Application Ref:	3/2025/0144	 Ribble Valley Borough Council www.ribblevalley.gov.uk
Date Inspected:	15/04/2025	
Officer:	MC	
DELEGATED ITEM FILE REPORT:		REFUSAL

Development Description:	Proposed extension and remodelling (with associated building works) to the existing barn, to create a detached dwelling (previously subject to approval 3/2023/0075). The erection of a detached double garage with habitable living space above, as an annexe to that family dwelling, and external works and change of use of land to residential curtilage.
Site Address/Location:	Tan Yard Farm, Ribchester Road, Hothersall, PR3 3YA

# PROPOSED BARN: ELEVATIONS

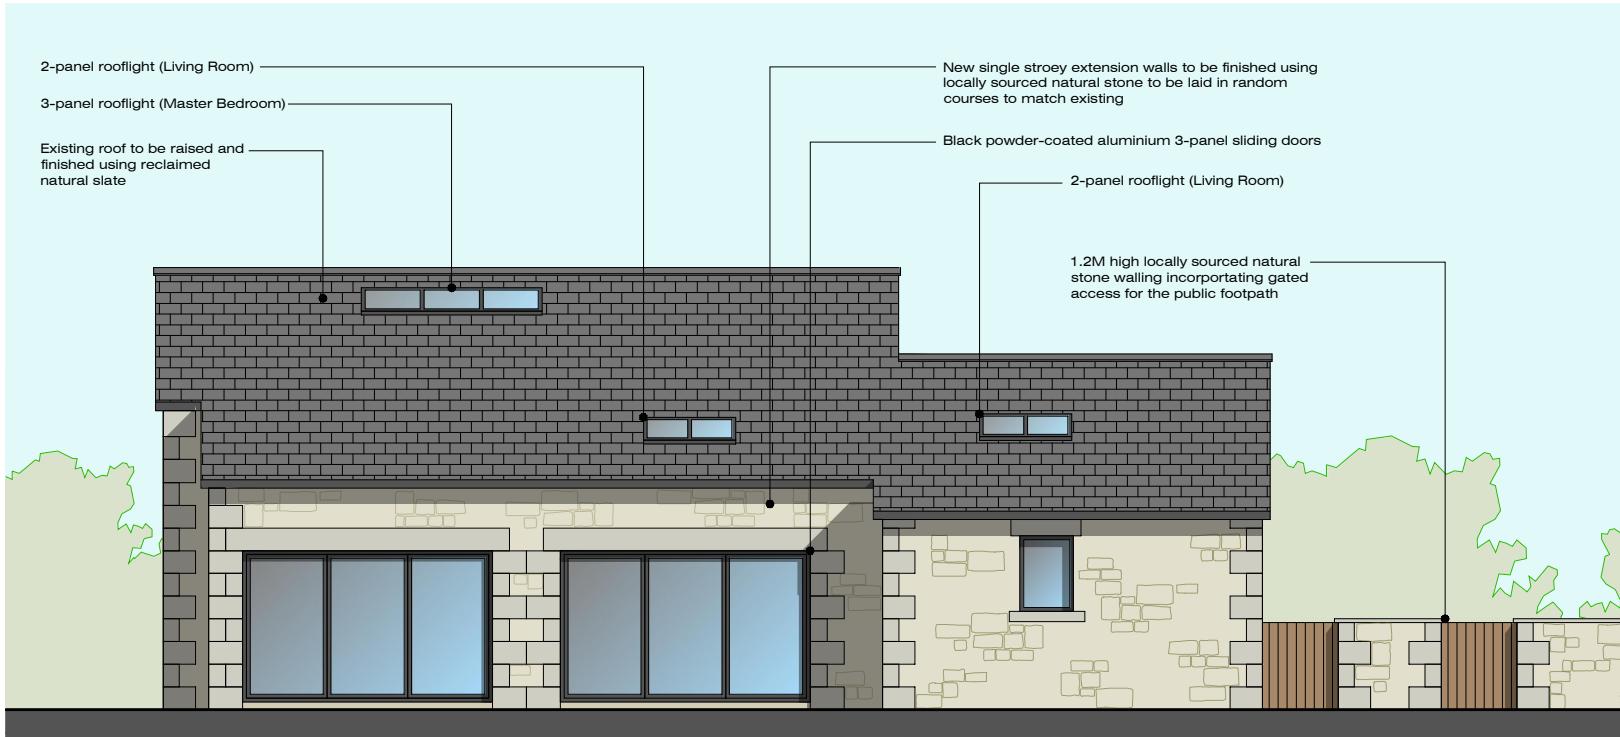
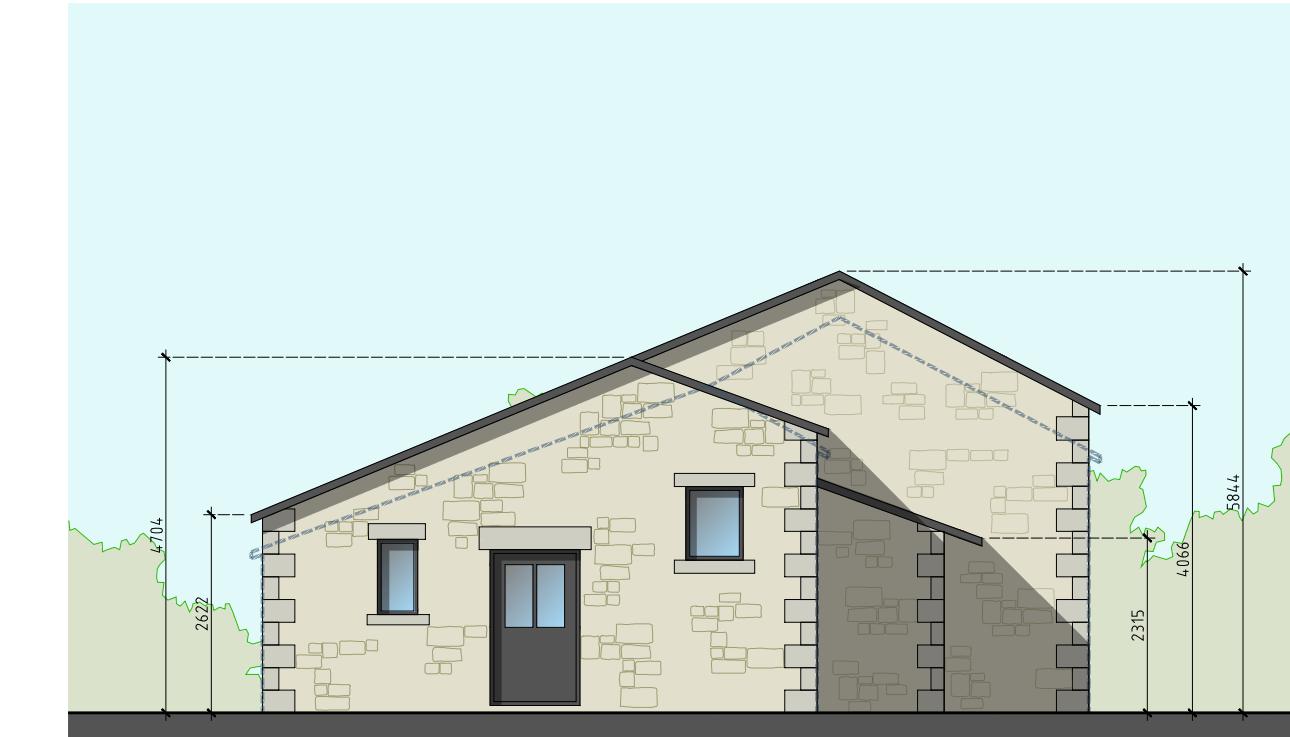
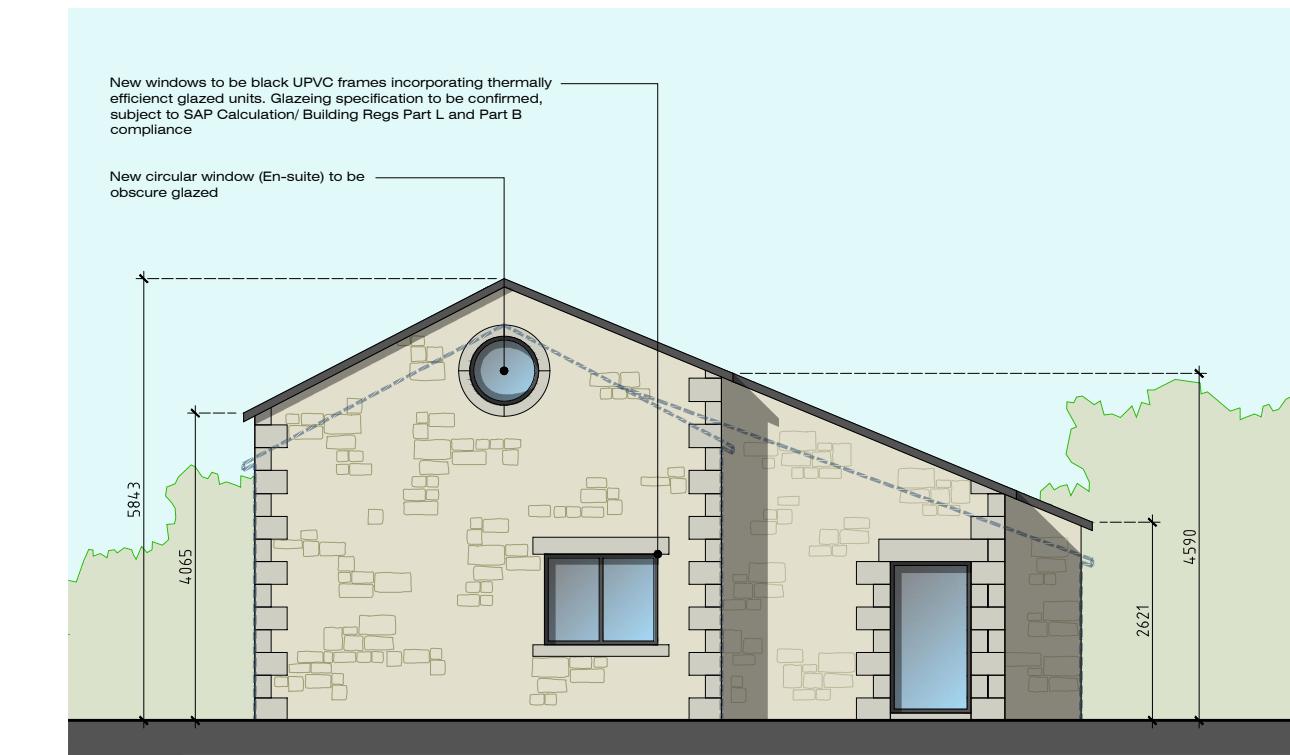
- No change to roof height of barn to be converted
- Insertion of small circular window to the side North-West elevation
- Amendments to door/windows design of barn
- Introduction of patio area adjacent to rear garden area of barn to be converted
- Increase in ridge height by approximately 0.93 metres to the garage
- Re-orientation of garage roof to a dual pitched roof with the gable to the front (South-West) elevation and rear (North-East) elevation.
- Increase in width of garage/annexe by approximately 0.35 metres
- Increase in eaves height of garage/annexe by approximately 0.1 metres
- Introduction of glazed apex feature to front (South-West) elevation of garage/annexe
- Introduction of 5 no. rooflights to garage/annexe
- Removal of soft landscaping features (Mulch/Bark with Karl Foerster Long Grass)

The proposed barn conversion would be approximately 34 metres to the South-West of the existing barn that is under conversion. Given that there would be no significant changes other than the insertion of a small round window which would not overlook any residential neighbours, it is not considered that there would be any detrimental harm to amenity. The proposed garage/annexe would be approximately 60 metres to the South-West of Tan Yard Farm and as such, this would not result in any adverse loss of light, overshadowing or overbearing impact. In addition, there are no windows proposed to the rear elevations which could directly overlook the occupiers.

The overall design of the barn conversion has already been agreed and as such, given the latest planning permission granted, there would be no objection to the overall remodelling. It is considered that the introduction of a small area of patio in front of the garden of the barn conversion is balanced by the removal of additional footpath/paving/patio outlined in the amended approved site plan for planning ref: 3/2023/0075. This is not considered to result in harm to the rural character of the site. In addition, the insertion of a new circular window to the flank elevation of the barn conversion is considered acceptable as it would be similar to the existing window at the barn conversion granted under planning ref: 3/2023/0075 and would therefore not be out of keeping with the character of the area.

**PROPOSED
SECTIONS X-X & Y-Y**

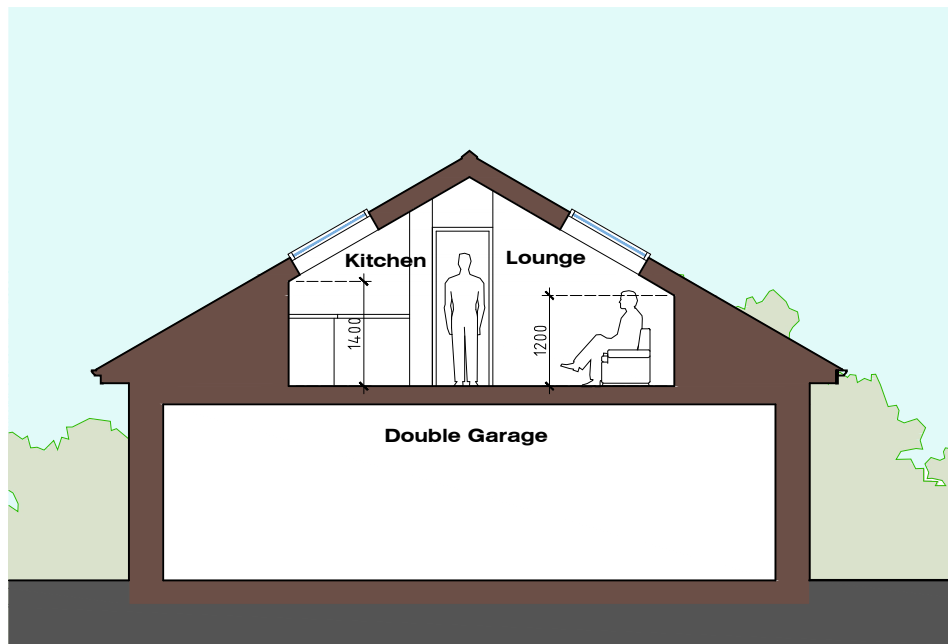
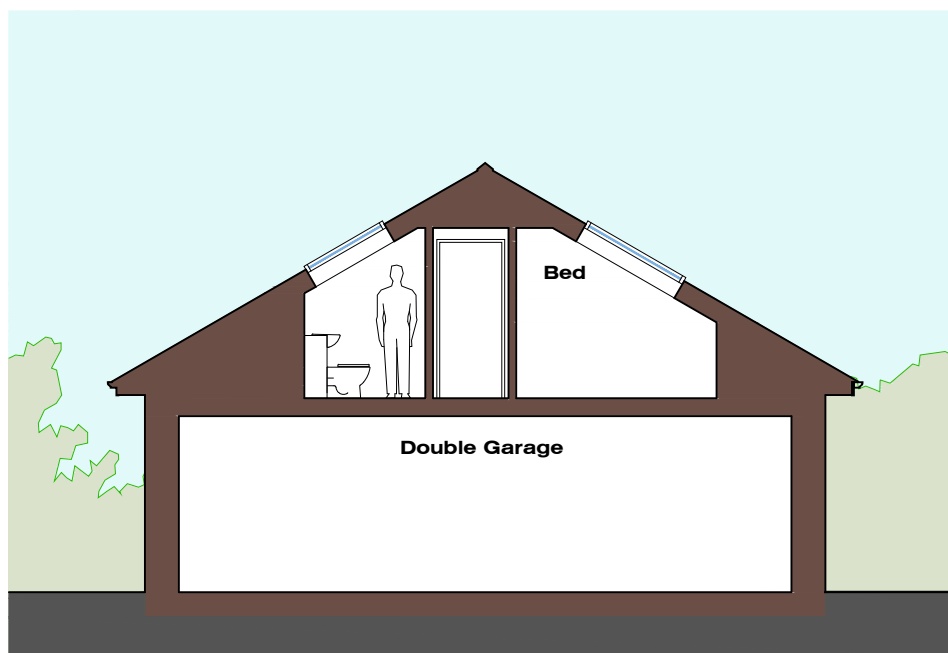
With regards to the size and scale of the garage/annexe, this would be approximately 0.93 metres taller than the approved garage. In addition, the change in orientation to the building, increase in width and insertion of the 5 no. rooflights is not considered acceptable and would add bulk and mass to the site that is considered to be detrimental to the rural character of the area. The proposed garage/annexe would be of a similar height to the main barn conversion and no longer reads as an ancillary building. The orientation of the building, means that when viewing the South-West elevation which is visible from the footpath which runs through the site, the large gable wall with a glazed apex window is highly prominent and is considered to compete in size and scale with the main dwelling when viewed from this elevation, resulting in an incongruous addition.

It is considered that the annexe could be utilised independently from the main dwelling as it accommodates a bedroom, bathroom, kitchen and living area as well as a separate downstairs W/C. In addition to this, the annexe would be physically separated from the main dwelling by a 1.2 metre high wall, making it appear more visually separated. The proposal would not appear subordinate to the principal dwellinghouse to be converted, nor would it read as a structure ancillary to the application property or be easily integrated into the main dwelling at a later date should circumstances change.
